From: Damian Sullivan
Sent: 17 January 2014 16:06
To: Planning.Responses
Subject: FW: 48 Pigeonhouse Lane R/277/13
Attachments: side elevation.pdf

From: Lauren Willard [REDACTED]
Sent: 16 January 2014 13:57
To: Damian Sullivan
Cc: 'Nigel Sturgeon'
Subject: 48 Pigeonhouse Lane R/277/13

Side Elevation (north)

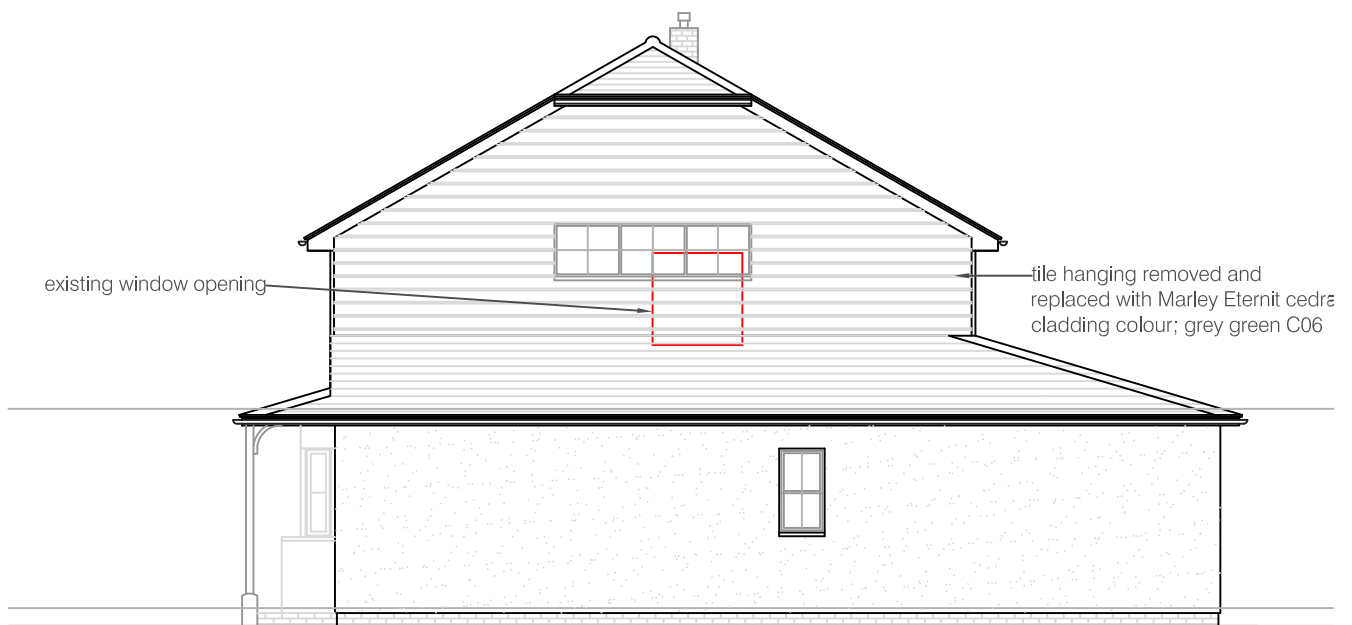
Please can the below text and attached plan be scanned in as part of the application concerning the first floor window on the side (north) elevation of the property.

Further to our telephone conversation earlier today. Please find attached the proposed North Elevation with the outline of the existing hallway window marked in red. I would like to confirm that the cill of the proposed window is 1700mm above first floor level with part of the window also being over the stairwell area. Therefore we consider the proposed window a vast improvement in privacy for the Neighbouring property (no.46 Pigeonhouse Lane)
